Planning Application No: 3/2021/1153 Grid Ref: 376632 444055

Proposal: Proposed dwelling with basement accommodation on an in-fill site adjacent to no 9 Old Road Chatburn, following refused applications 3/2019/0498 and 3/2020/0145.

Location: land adjacent to no 9 Old Road Chatburn BB7 4AB

project	project number	drawing number
11 Old Road	1909	Ex 02
name		
scale	date	status
1 to 200 @ A3	29.07.21	planning
		revision
		B

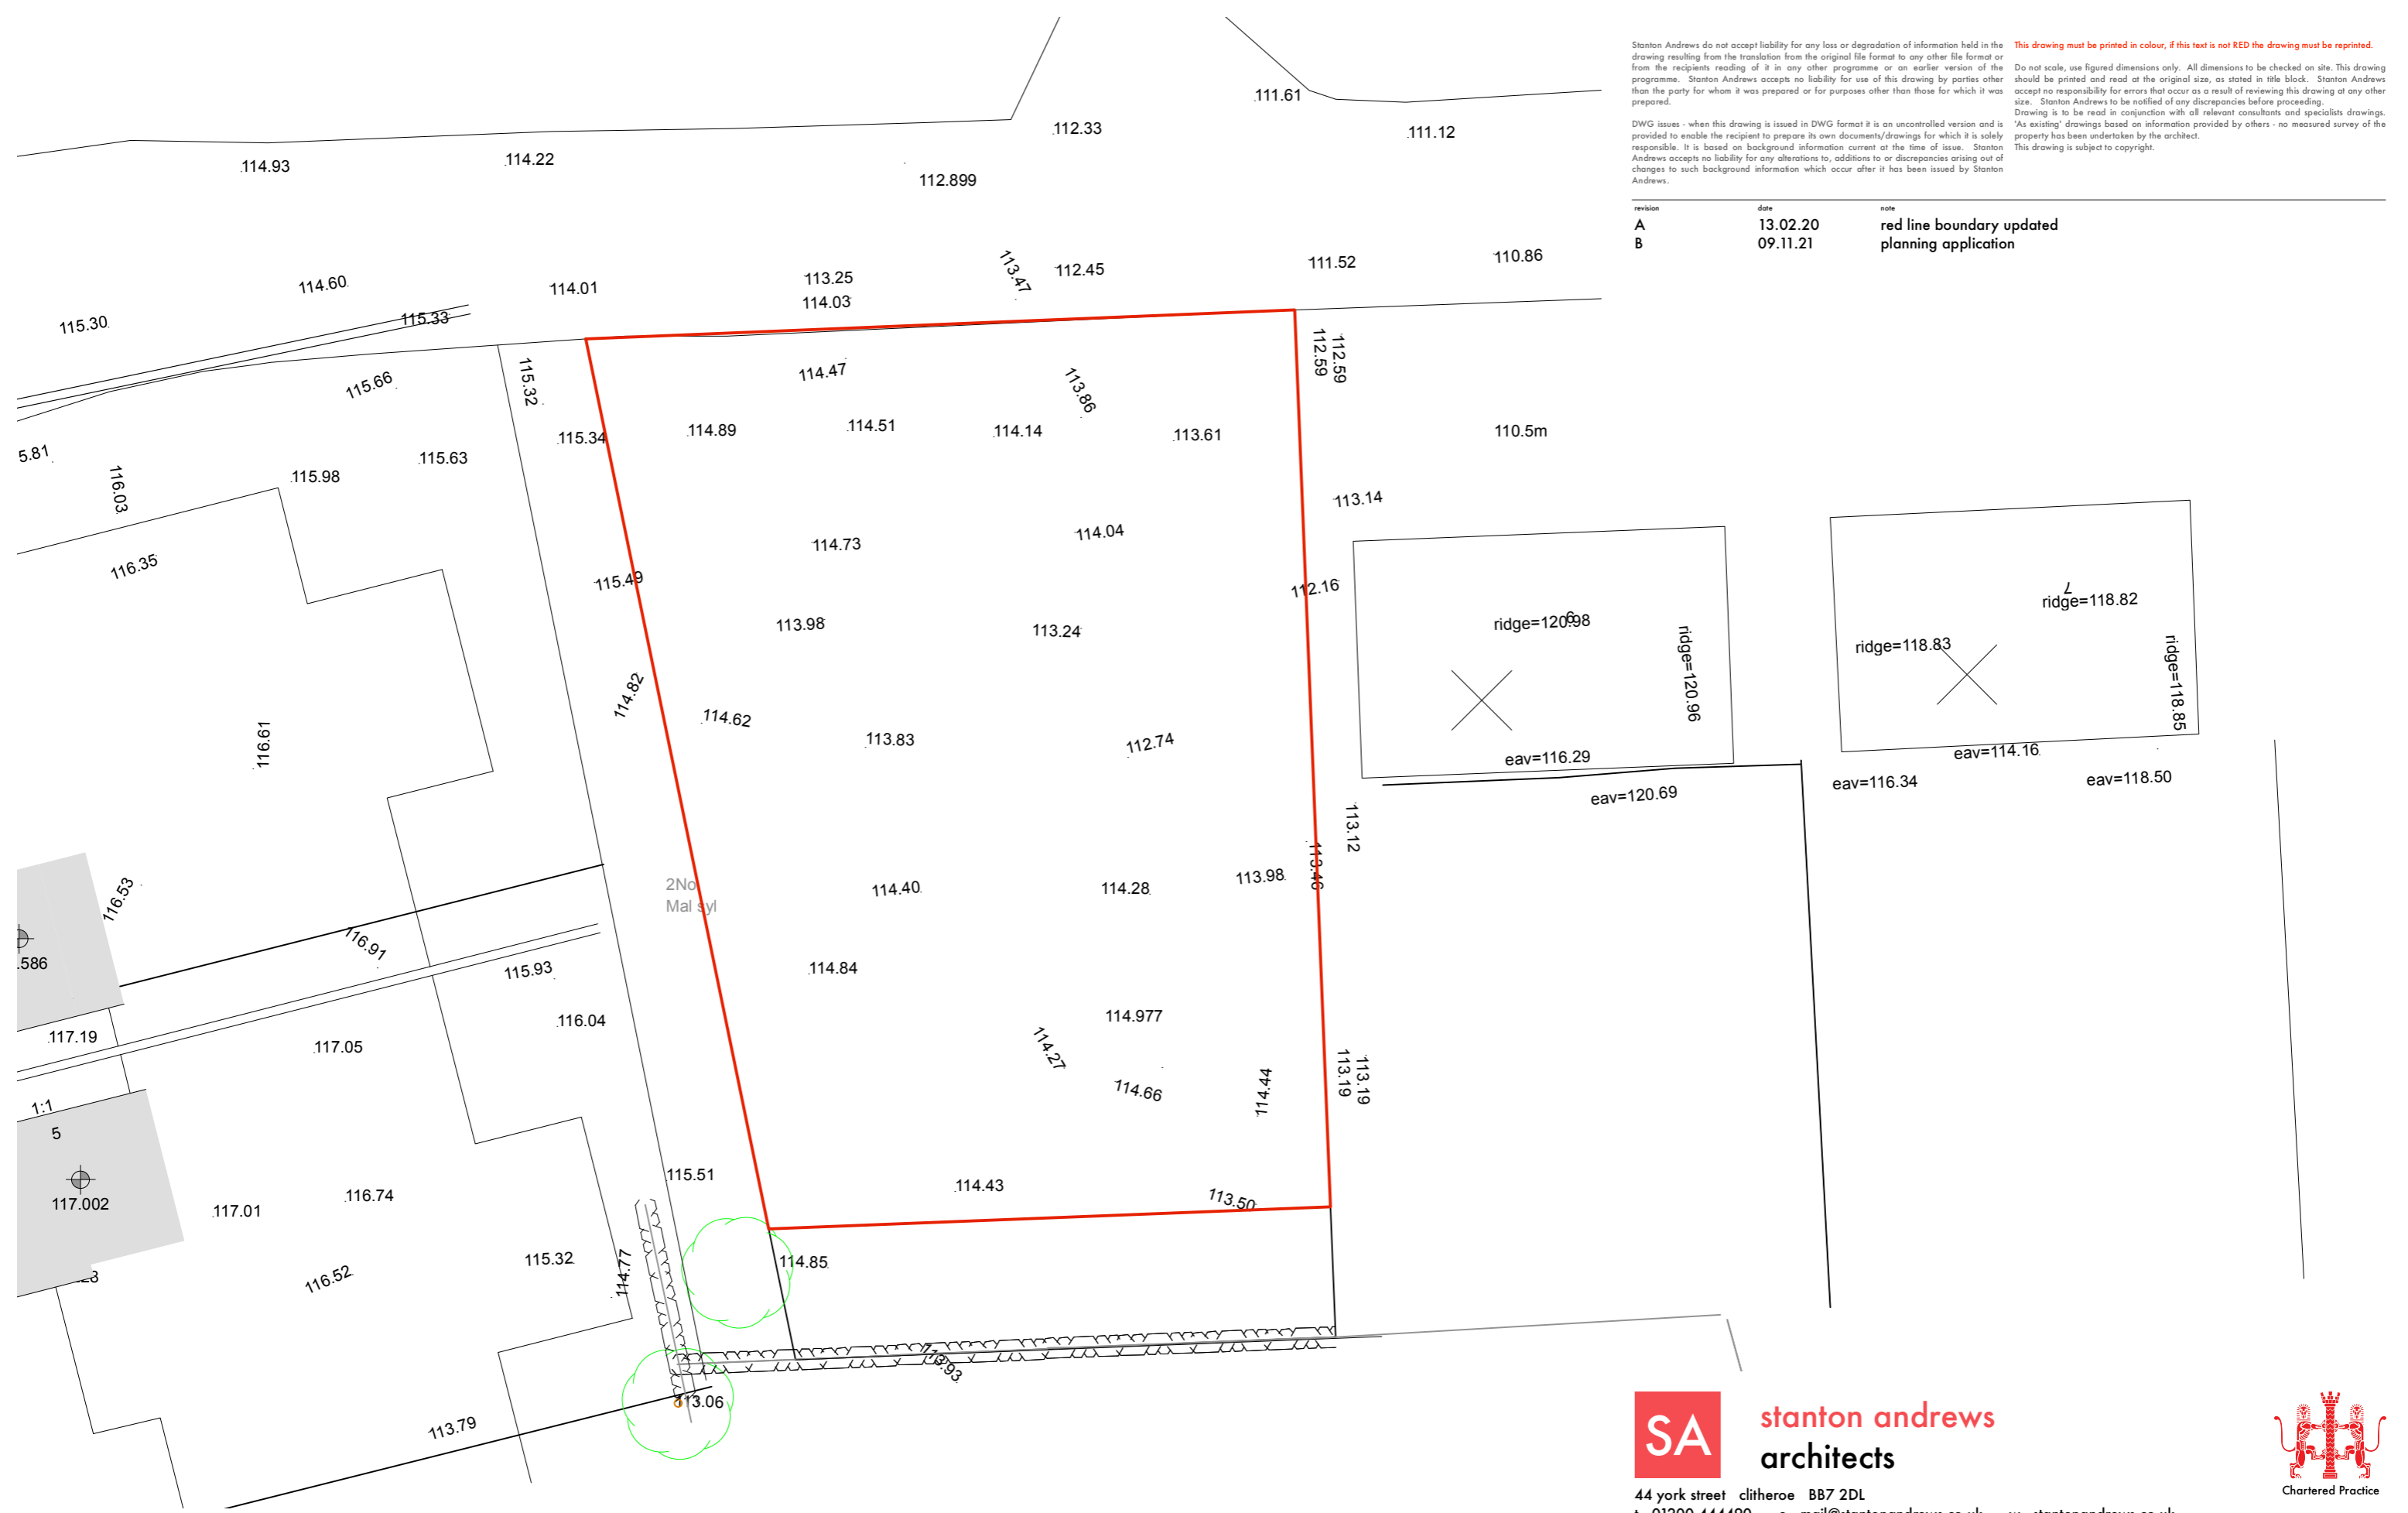
i The existing site plan details a hedge running parallel to the southern boundary of the application site and 2 trees immediately to the south west, neither of which exist, and omits trees and shrubs in the vicinity of the road frontage

ii The existing site plan and location plan are inaccurate in respect of the boundary line of properties abutting to the west, an error which is transferred to the proposed site plan

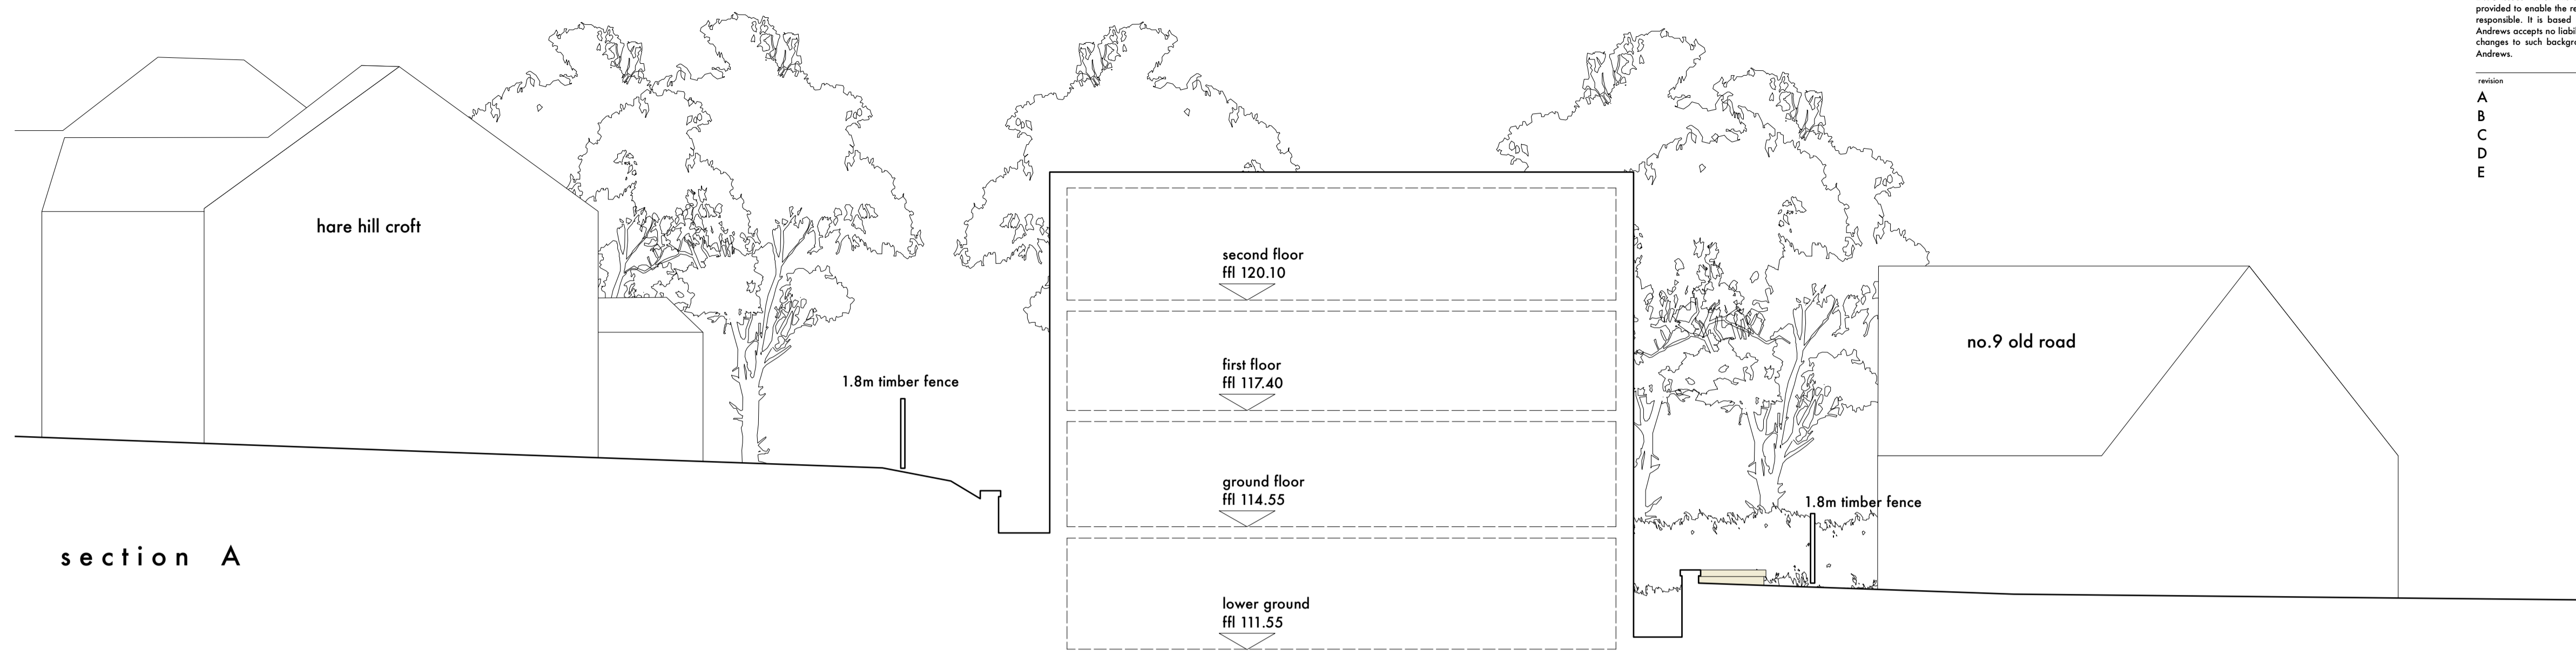
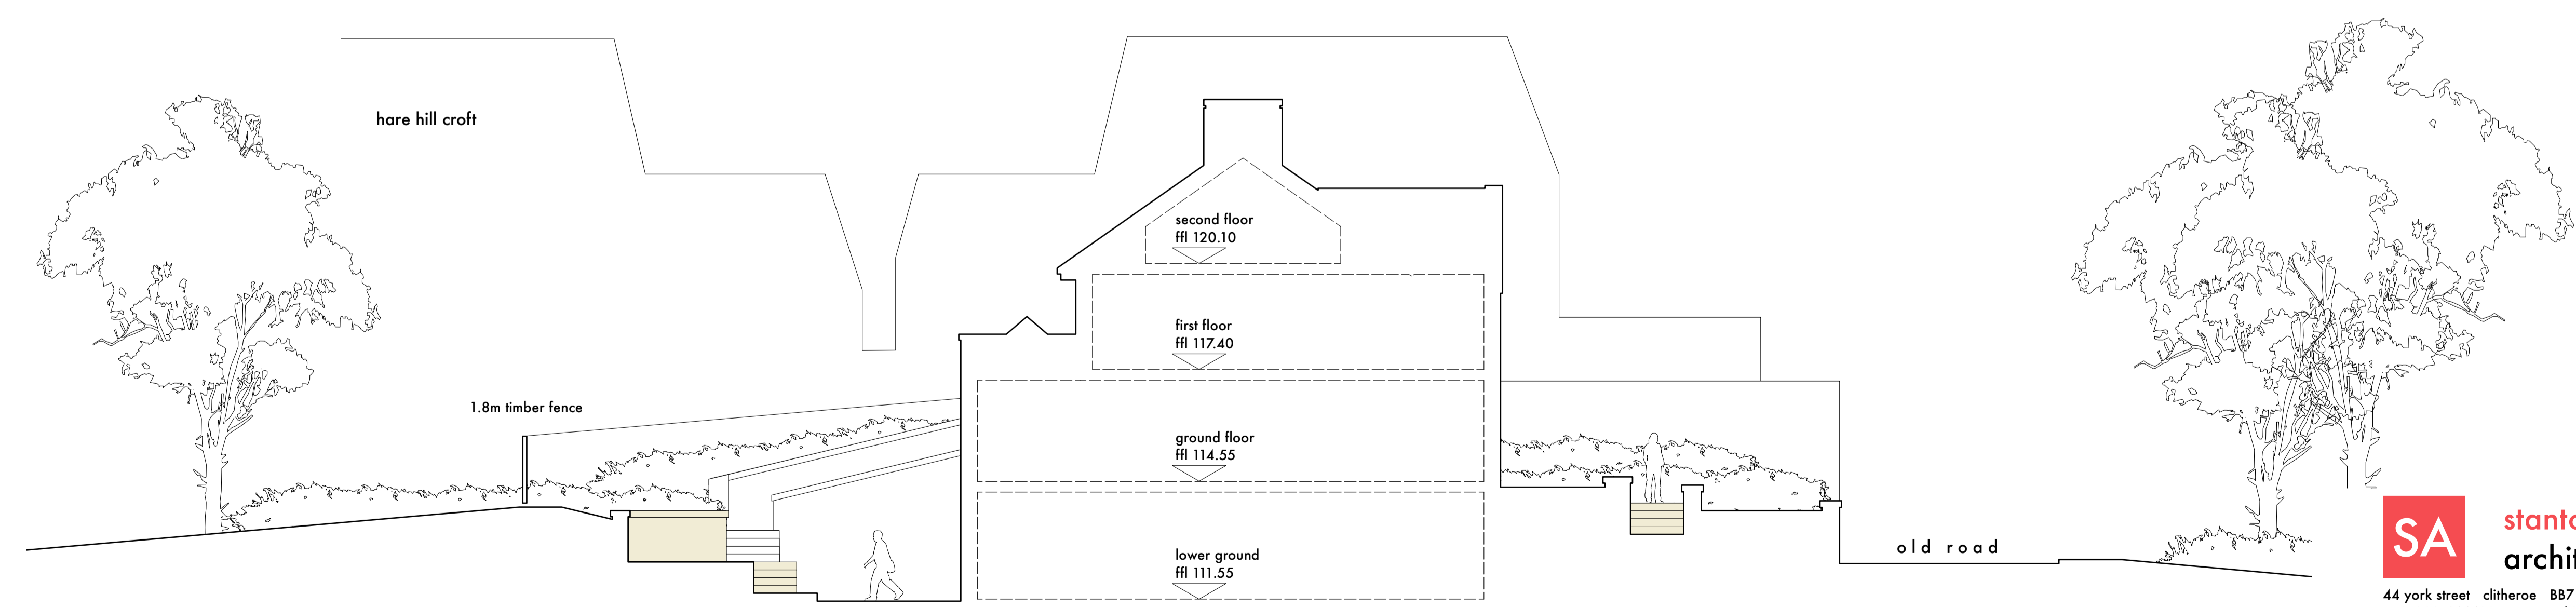
Proposed Sections

1. The basement level is indicated at a proposed level of 111.55m. The levels and positions of No's 1 & 2 HHC as drawn do not show the most onerous cross sections in terms of level difference at the nearest plan position and are somewhat misleading in this regard. Cross sections showing the minimum widths to the HHC boundary and the maximum level change between proposed and existing should be shown along with structural details. The ground floor level of No.2 HHC is circa 117m which is an indicative level difference of circa 5.5m to the lower basement/patio level of the proposed dwelling

2. There is a note on the drawing *"C 15.07.19 gabion basket boundary wall updated"*. There is no reference to a gabion wall on the drawing. What is this and what boundary treatment is now proposed?

3. The retained height and proximity between the HHC properties and the proposed works is technically significant and engineering details of how this level difference is to be designed and constructed is warranted. Full details of the retaining structure, construction sequence and any temporary works proposals will be required to assess whether what is proposed is technically feasible.

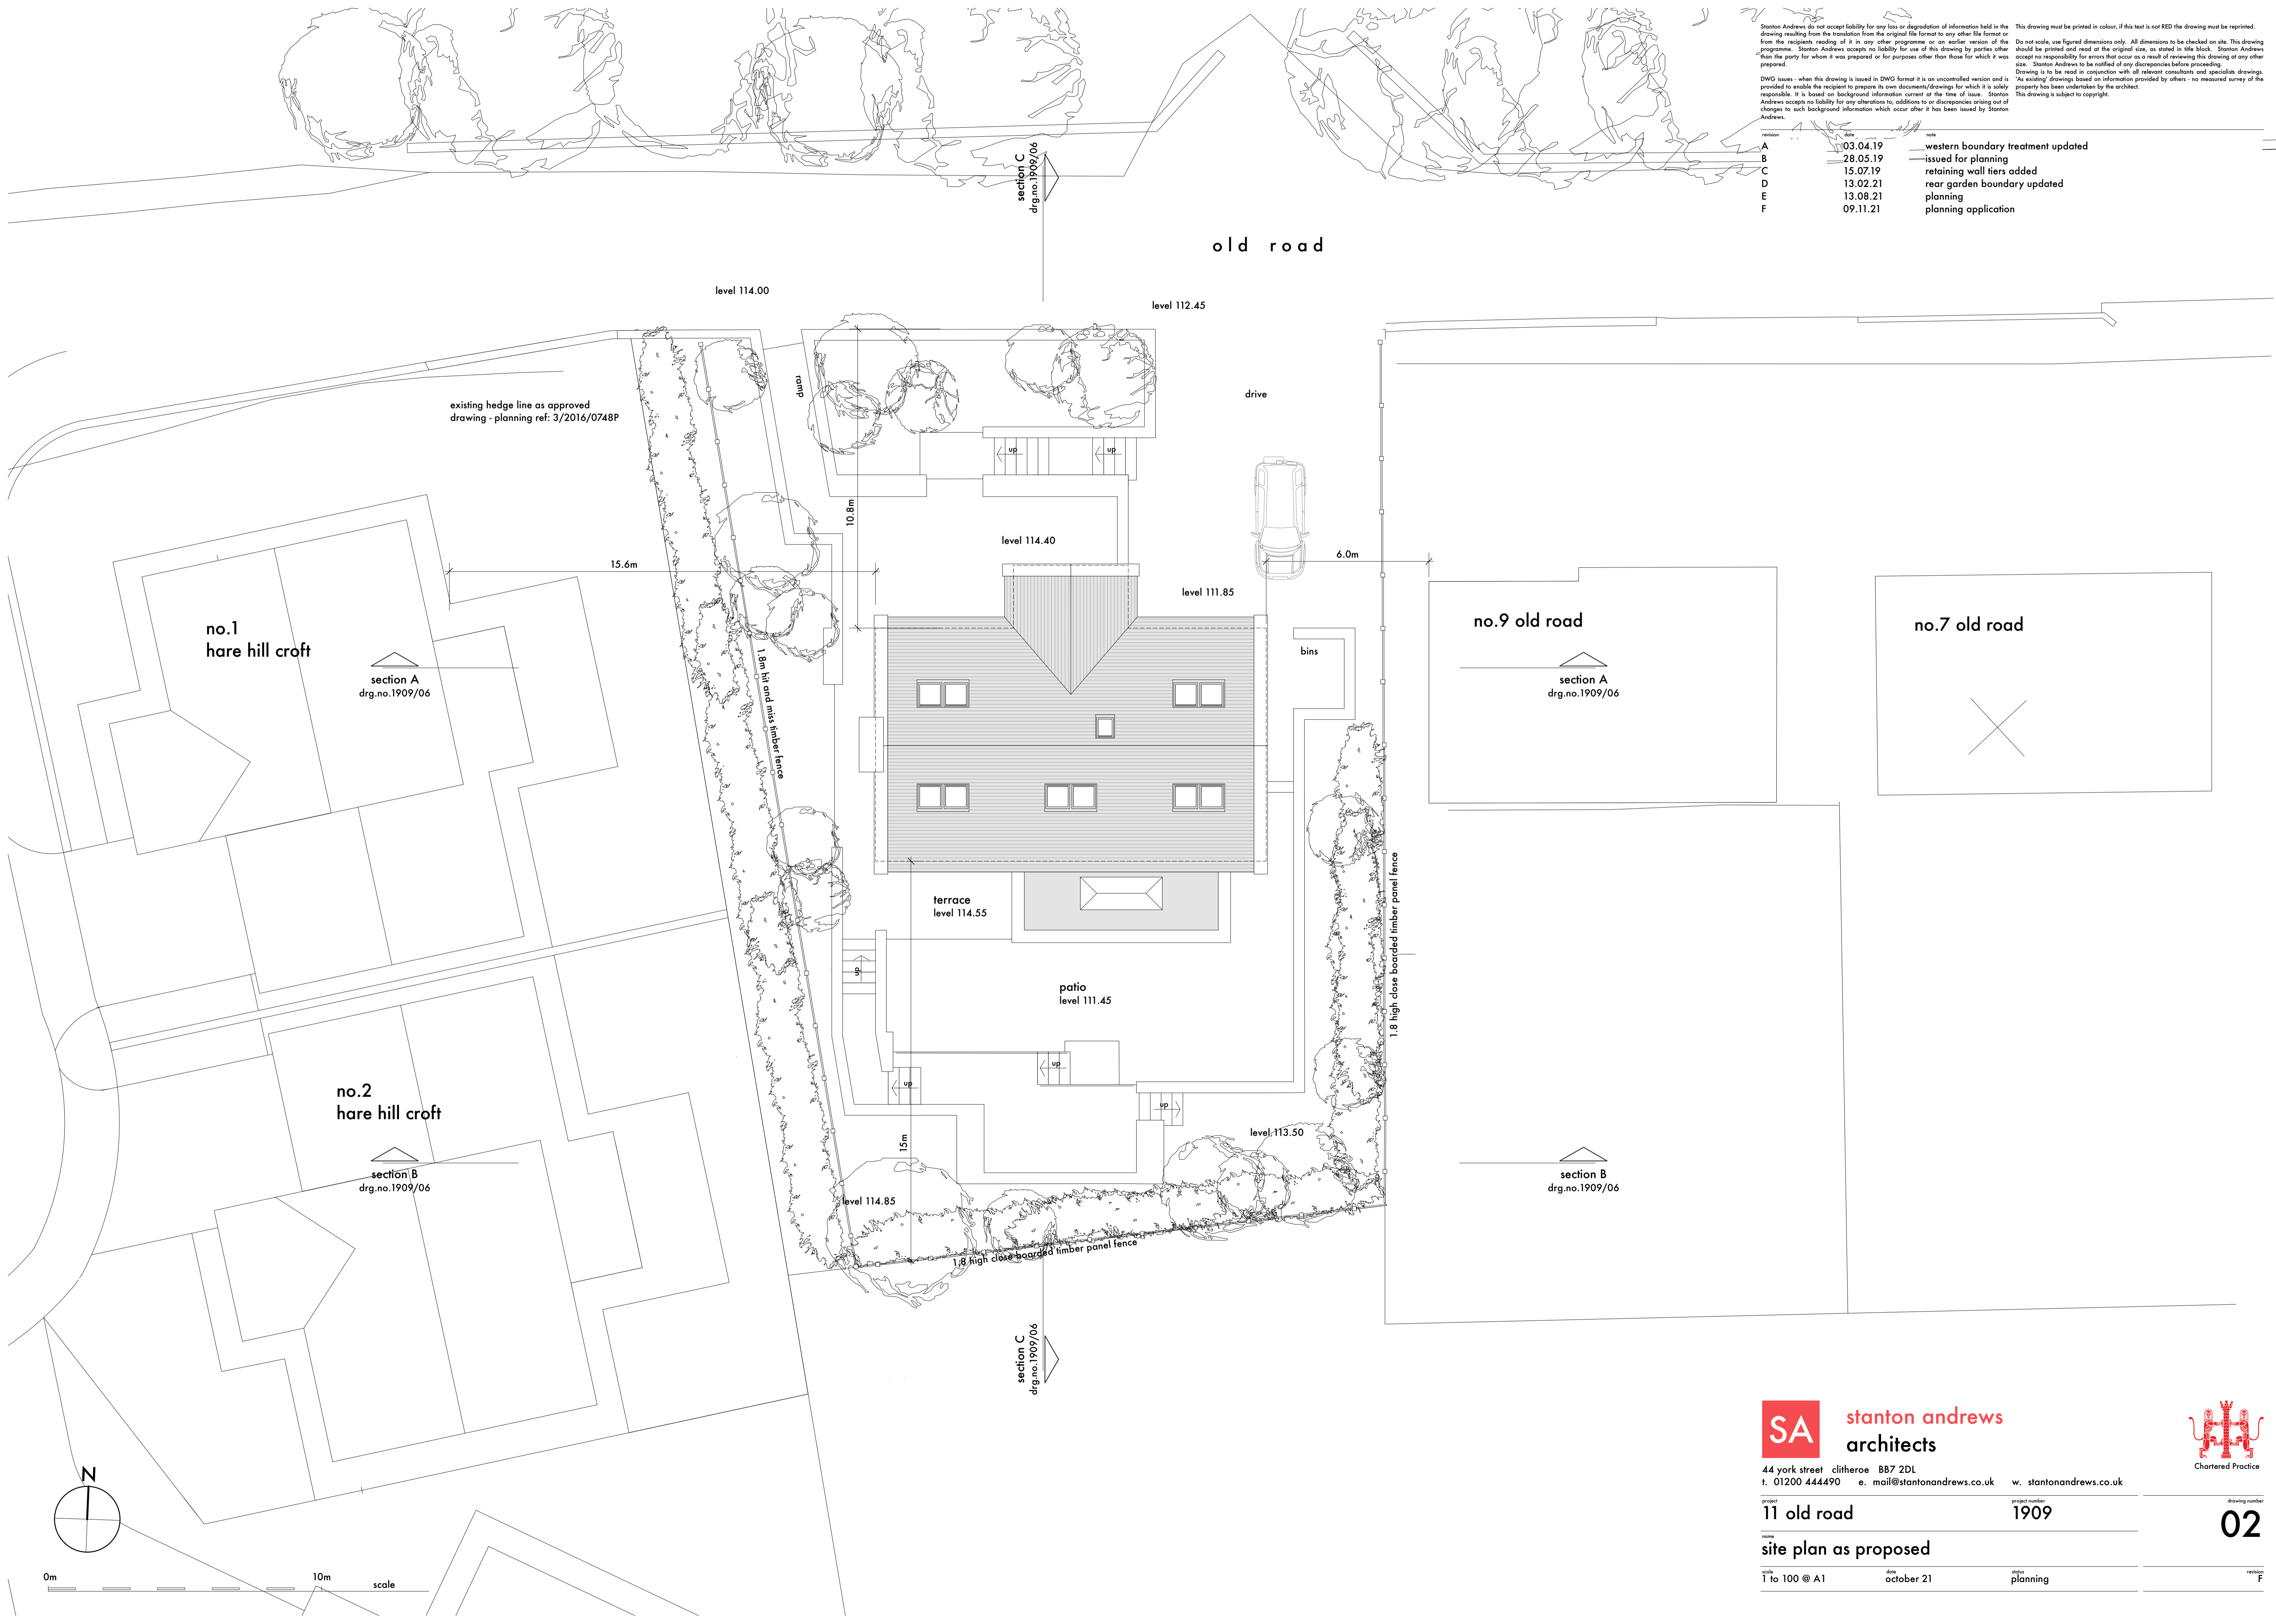
Proposed Site Plan

1. The land boundary along the eastern edge of No.2 HHC is incorrect and encroaches further east and beyond the line shown on the drawing. Show the correct land ownership boundary along the edge of the HHC properties.
2. The drawings refer to an *"existing hedge line as approved drawing - planning ref: 3/2016/0748P"*. This hedge line hasn't been installed in accordance with the HHC planning approved landscape plans.
